## Application for a Non-Material Amendment Following a Grant of Planning Permission

FRONT FIRST FLOOR EXTENSION OVER GARAGE

22/00222/FULL

CHANGE MATERIALS FOR THE WALL FINISH OF THE EXTENSION AND THE ORIGINAL GARAGE FROM RENDER (AS APPROVED) TO BRICKWORK

FRONT ELEVATION

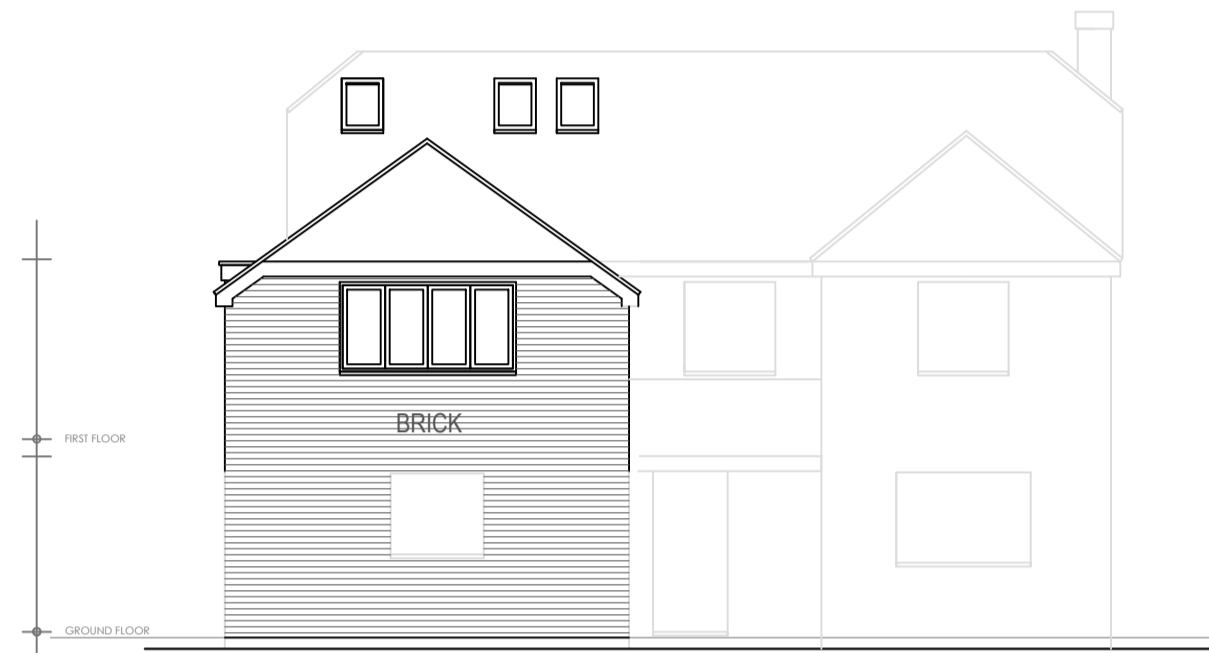
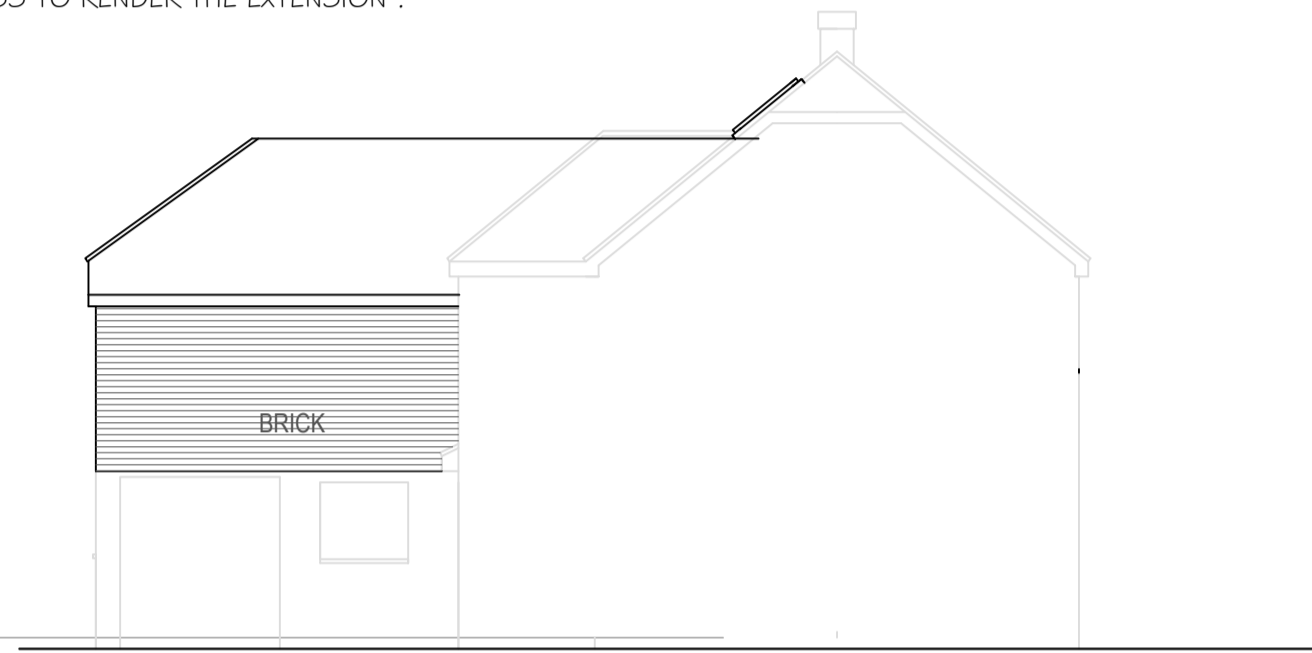
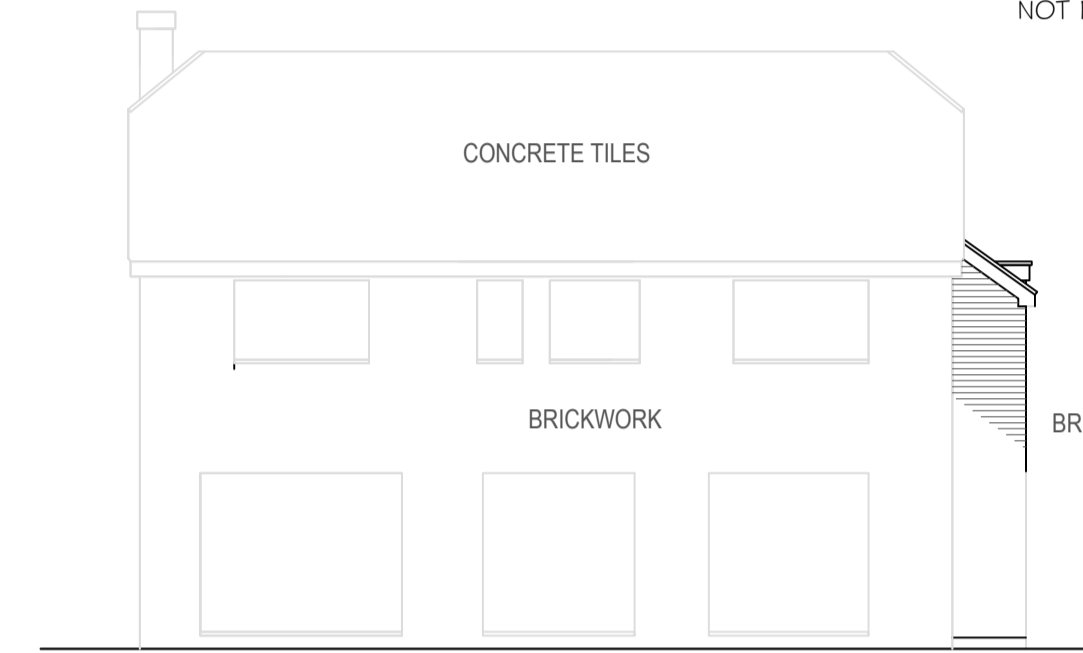
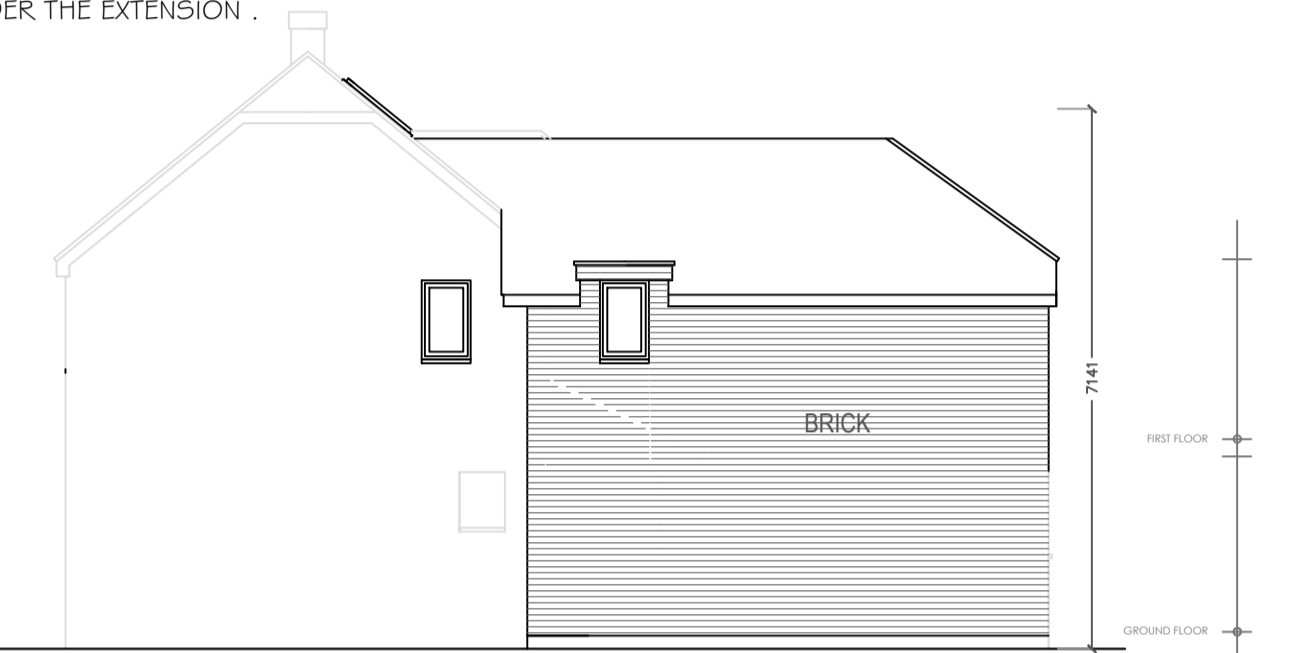
THE NEIGHBOUR AT 143 NORSEY ROAD WILL NOT PROVIDE ACCESS TO BE ABLE TO RENDER THE WALL SO WILL HAVE TO BE BUILT OVER HAND FROM WITHIN THE APPLICANTS' PROPERTY
